Letter of Intent for Special Use Permit

El Paso County

Re: Application for Special Use Permit – Accessory Metal Building (40' x 80' x 16') on 4.77-Acre Parcel, Zoned RR-5.

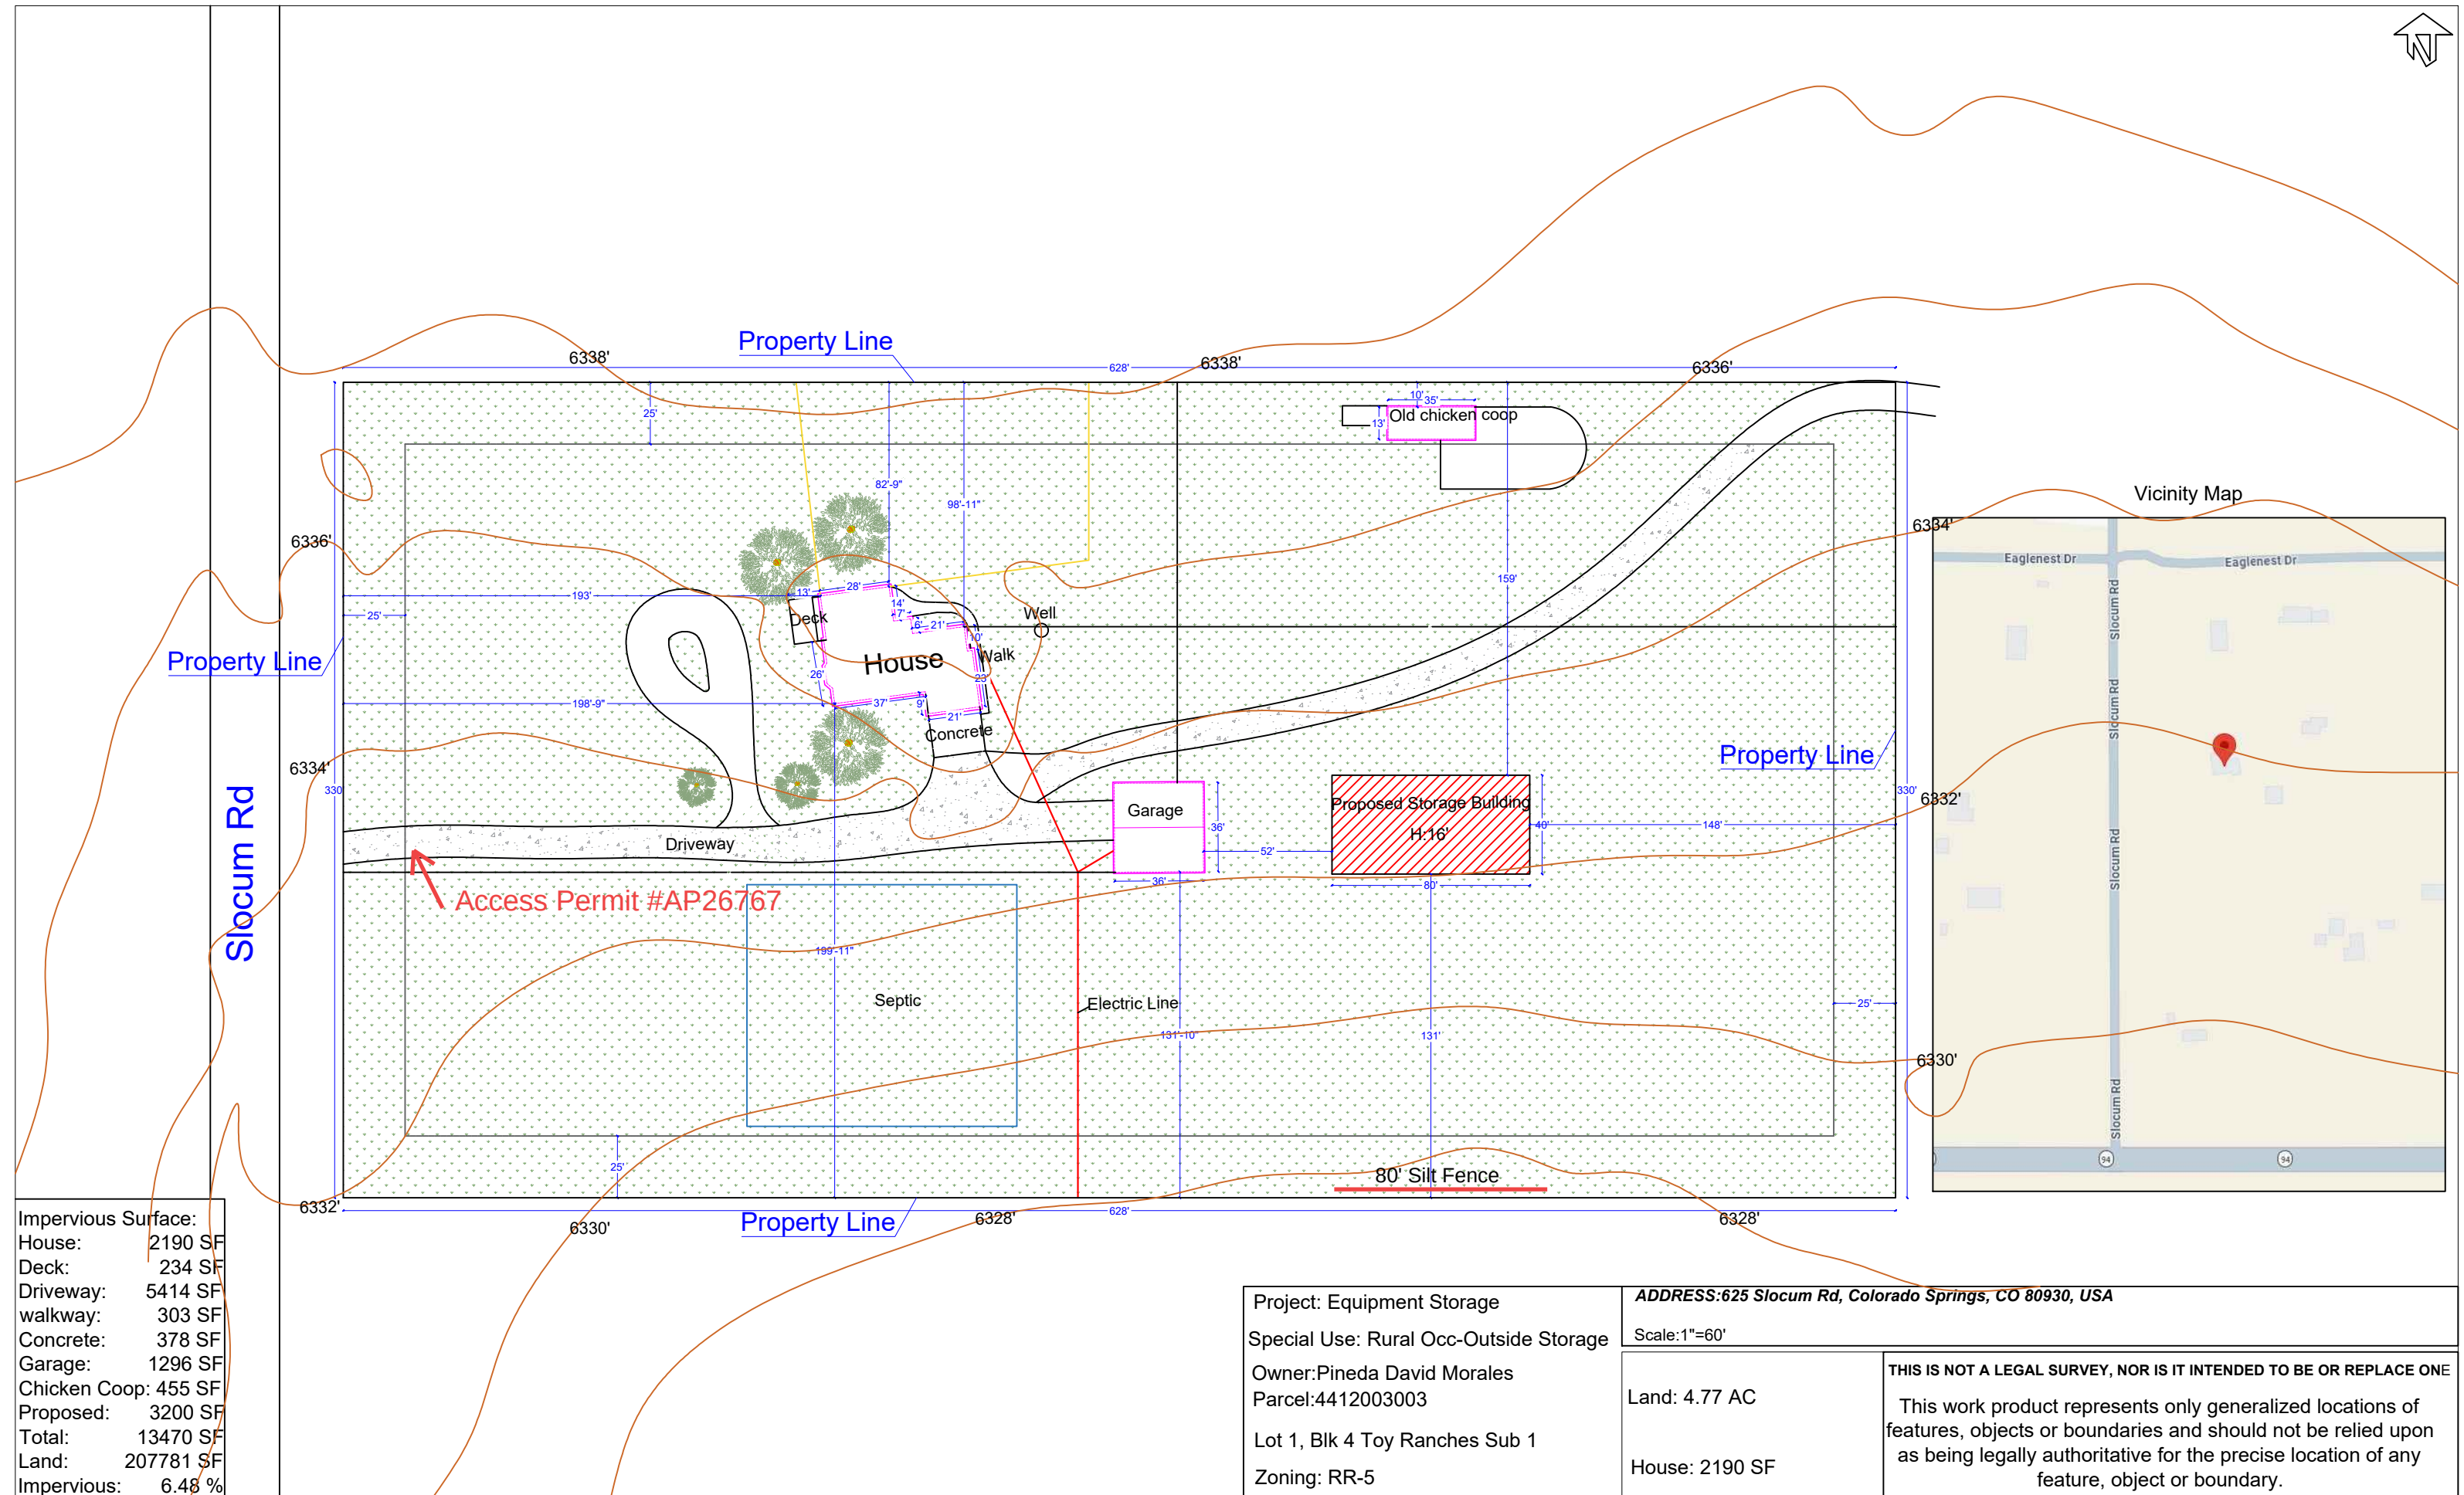
Drainage wasn't addressed here nor on the site development Plan. Please protect the property to the south from the construction activities.

this is where you confirm them. employee traffic, lighting, parking, outside storage if any, calculation of allowed and requested structure size (based on 2x primary residence footprint in Accessory Use and Structure standards in Land Use Code)
